Ribble Valley Borough Council  
By email

Your ref 3/2024/0134  
Our ref DC/24/714  
Date 04-APR-24

**Location: Black Bull Inn, Old Langho Road, Old Langho, BB6 8AW.**

**Proposal: Proposed change of use of adjacent agricultural field to car park and change of use of existing room.**

SHEET: PROPOSED SITE PLAN

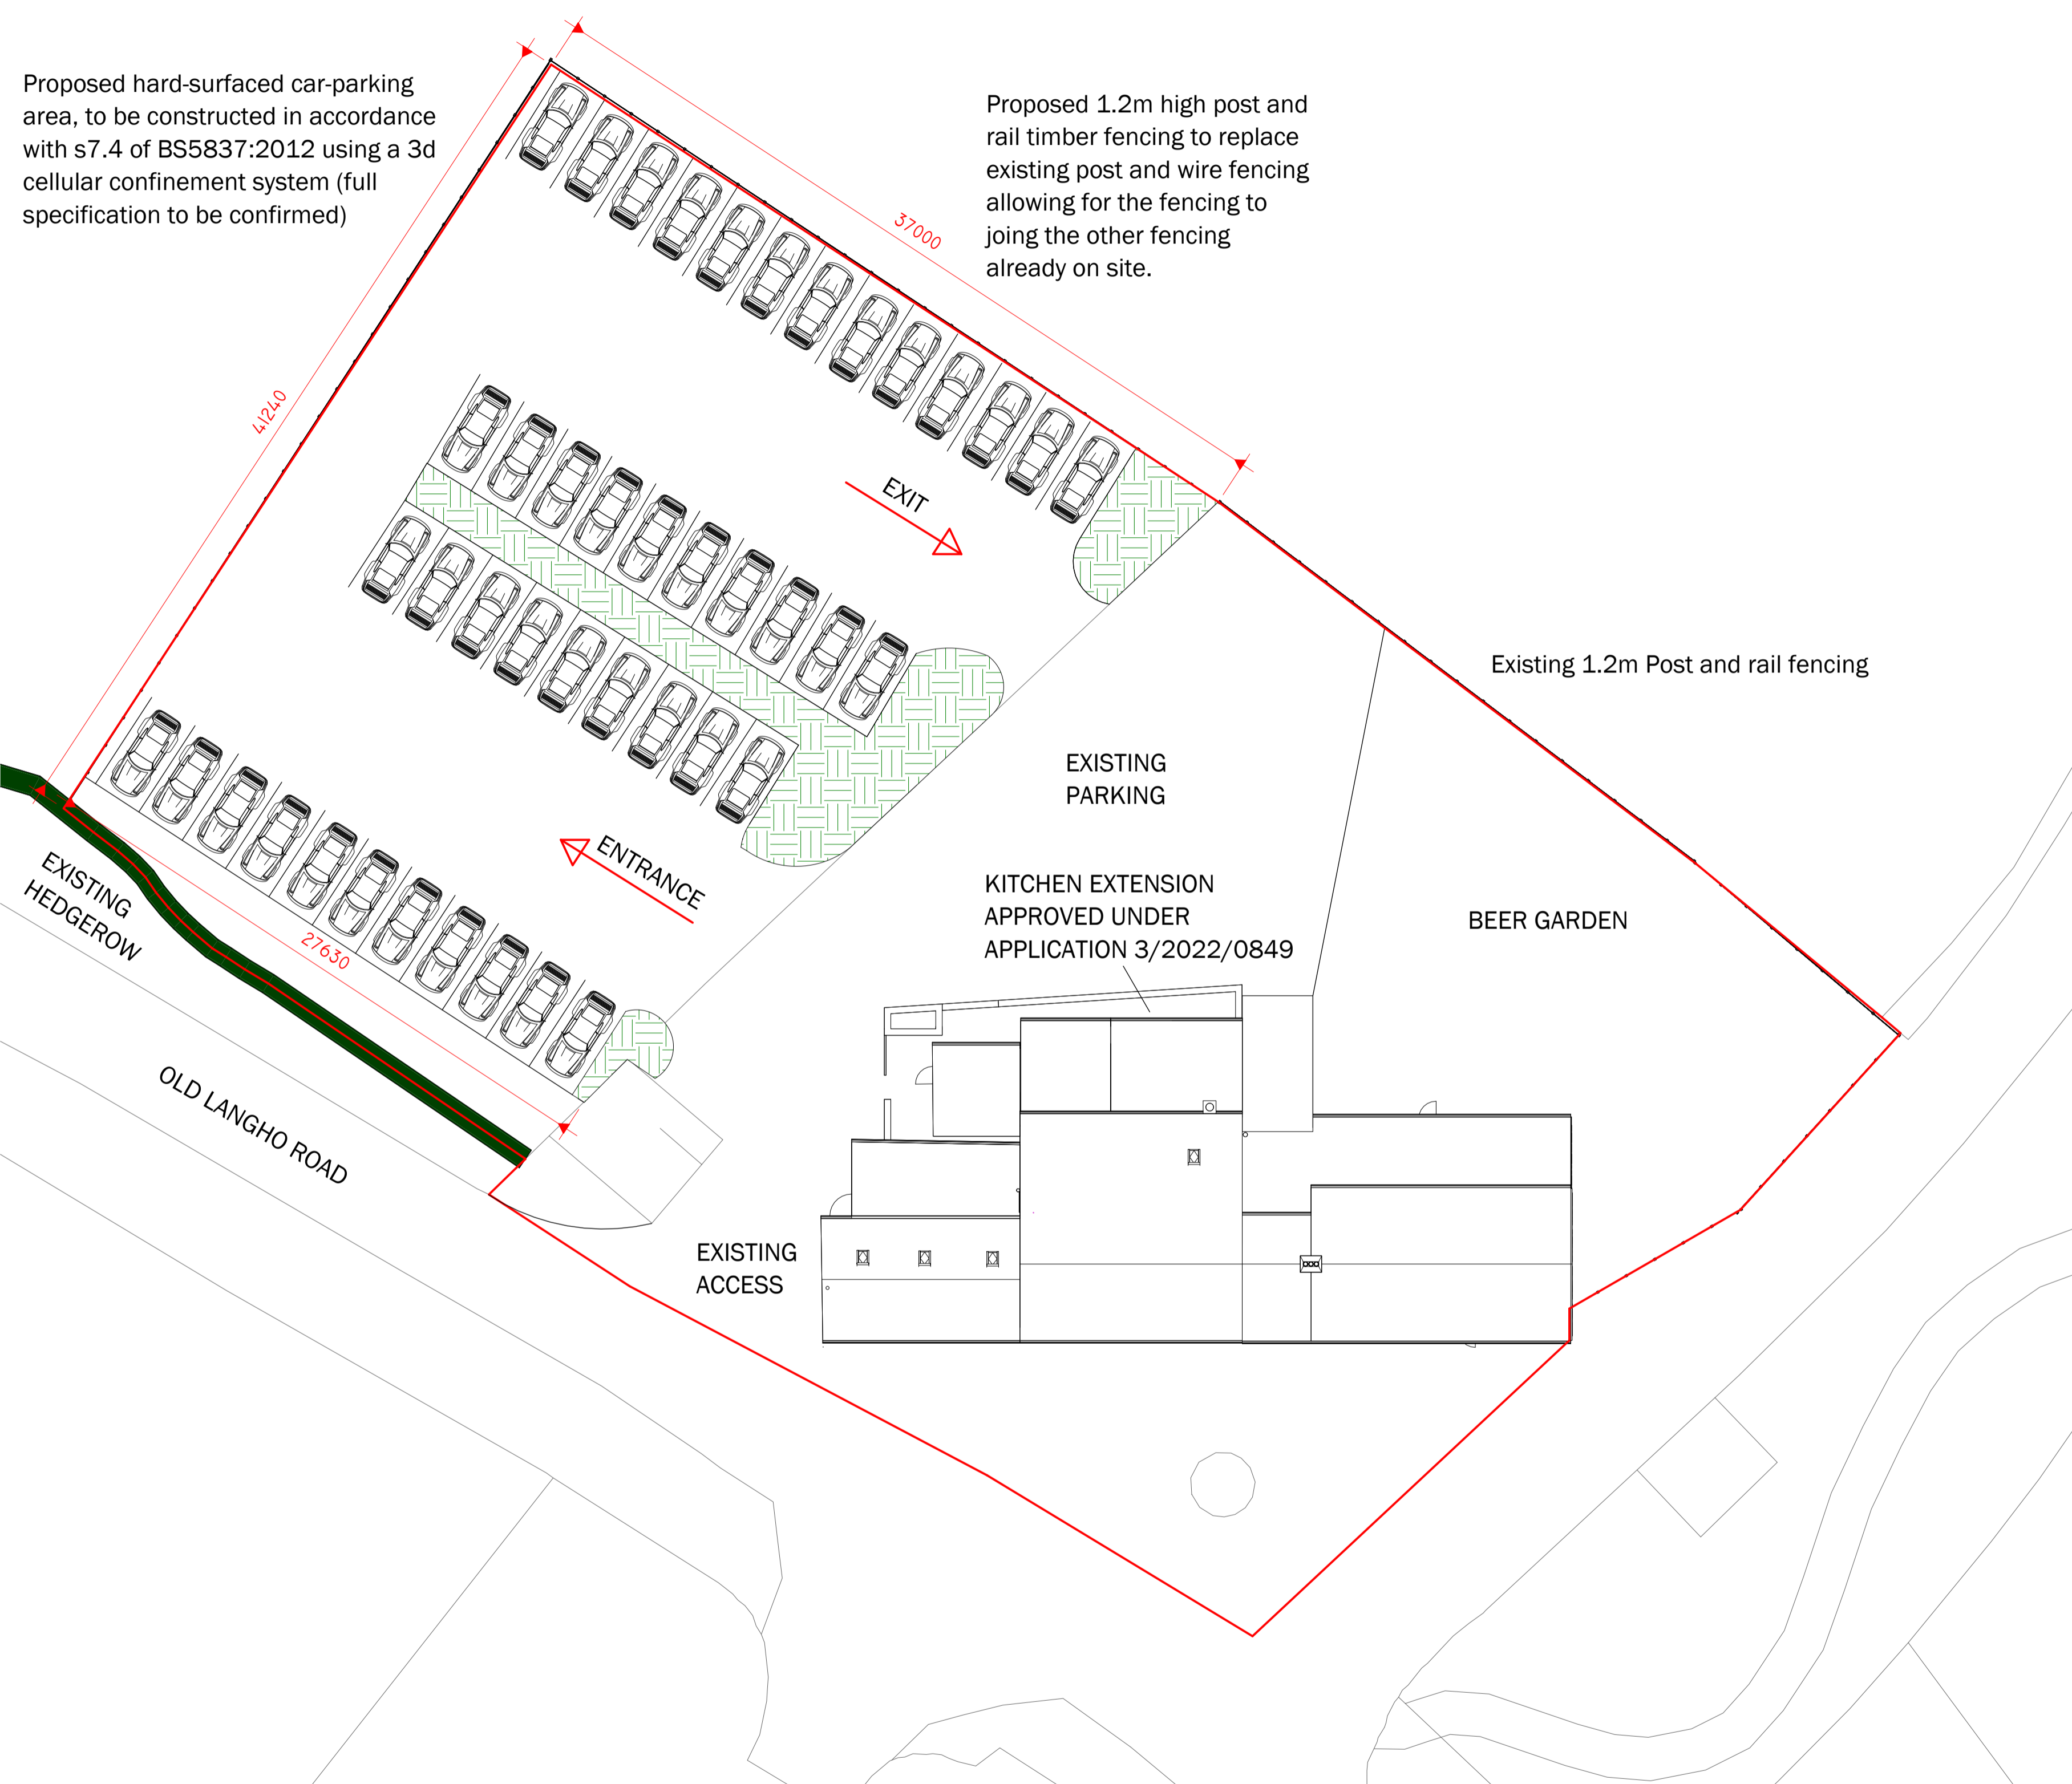
A public sewer crosses the site and we will not permit building over it. We require an access strip for maintenance or replacement and this access must not be compromised in any way. The minimum distances that might be acceptable to United Utilities are detailed within Part H of the Building Regulations however, we recommend the applicant determines the precise location, size, depth and condition of the pipeline as this is likely to influence the required stand-off distance from any structure.

Based on the information currently available, it is unclear whether sufficient distance is provided between proposed development features and our wastewater asset(s). We recommend the applicant contacts our Developer Services team to ensure existing wastewater assets, along with our required access widths, can be accommodated in the proposed layout. If the applicant fails

to investigate and resolve any concerns prior to a positive determination, there is a risk that as the scheme progresses, the applicant, or any subsequent developer, may discover that their plans are not implementable in their existing form or that diversion of assets is required. If the Local Authority requires any additional comment on the acceptability of the proposed layout from United Utilities, we will require a detailed site layout plan, which overlays the PROVEN location of the wastewater asset(s) in relation to any proposed development (including walls, fencing, parking etc.).
